LOT 1 AT CROSSROADS MIXED-USE FILING NO. 3

Site Development Plan

PPR2445

SITE PLAN

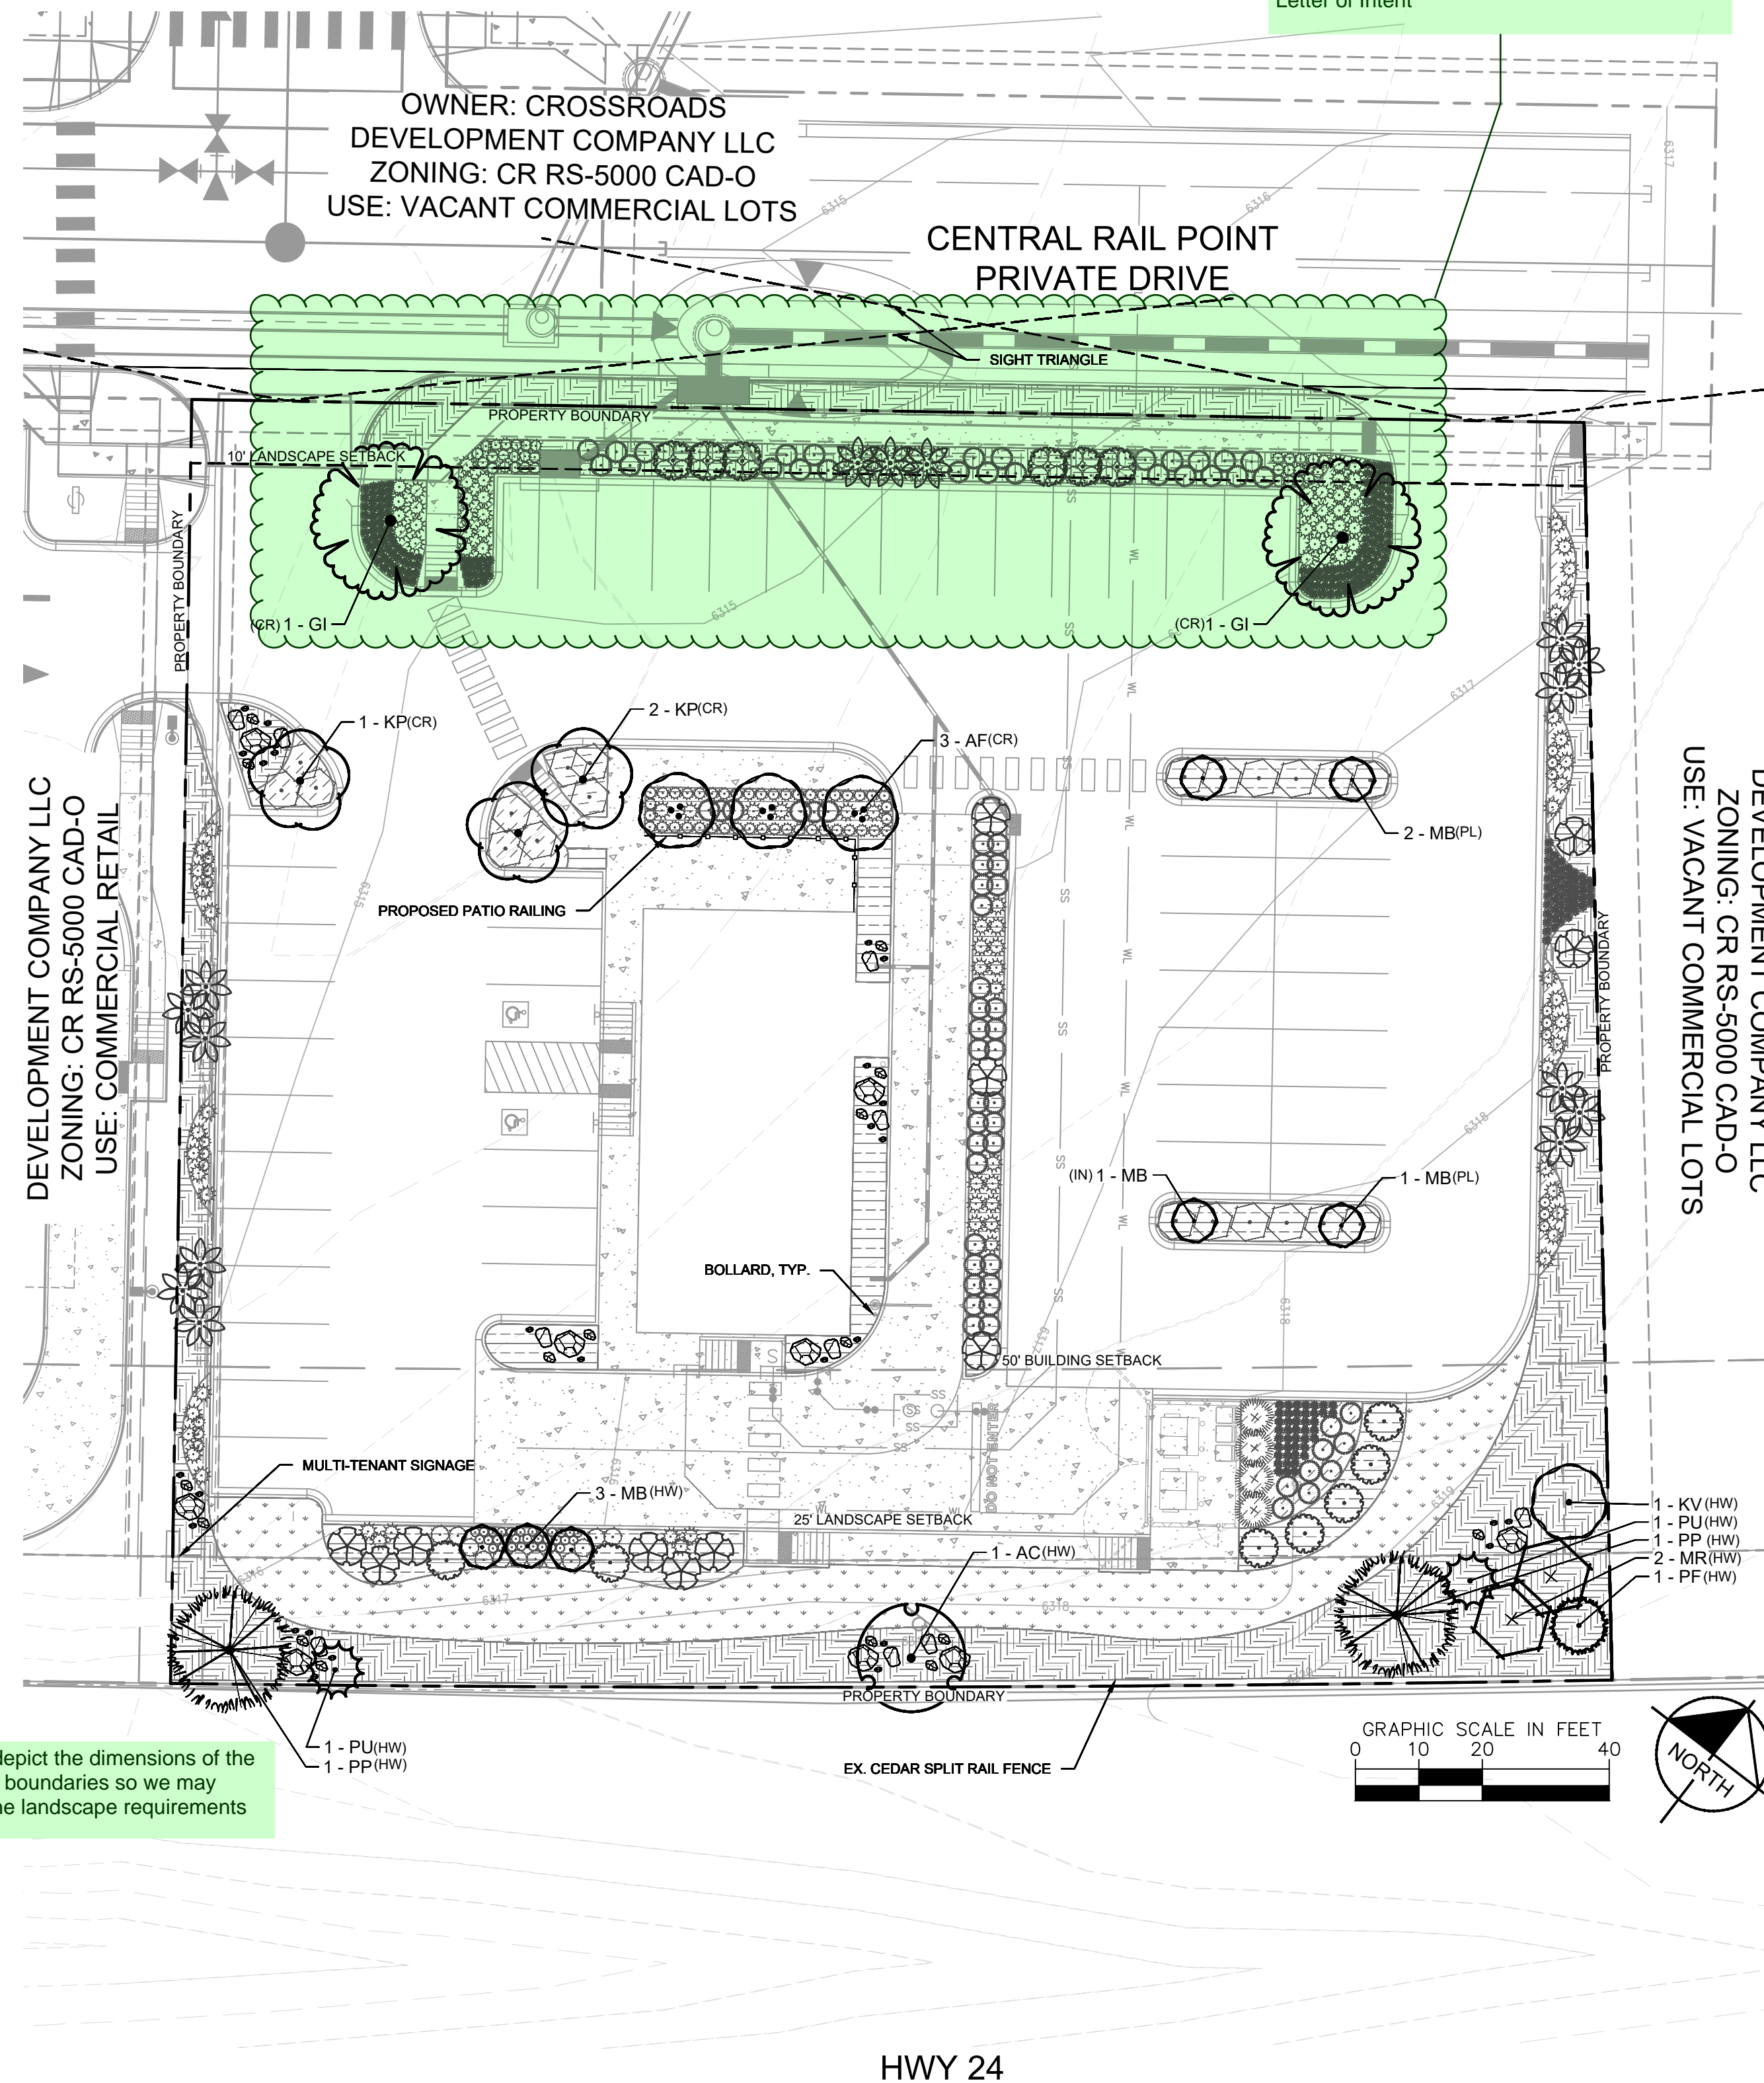
Plans indicate 47 spaces, please clarify

Please indicate where these are on the site plan

Please clearly indicate the points of ingress/egress and the proposed flow of traffic on the property

Please clearly depict property boundaries on the NE and NW edges
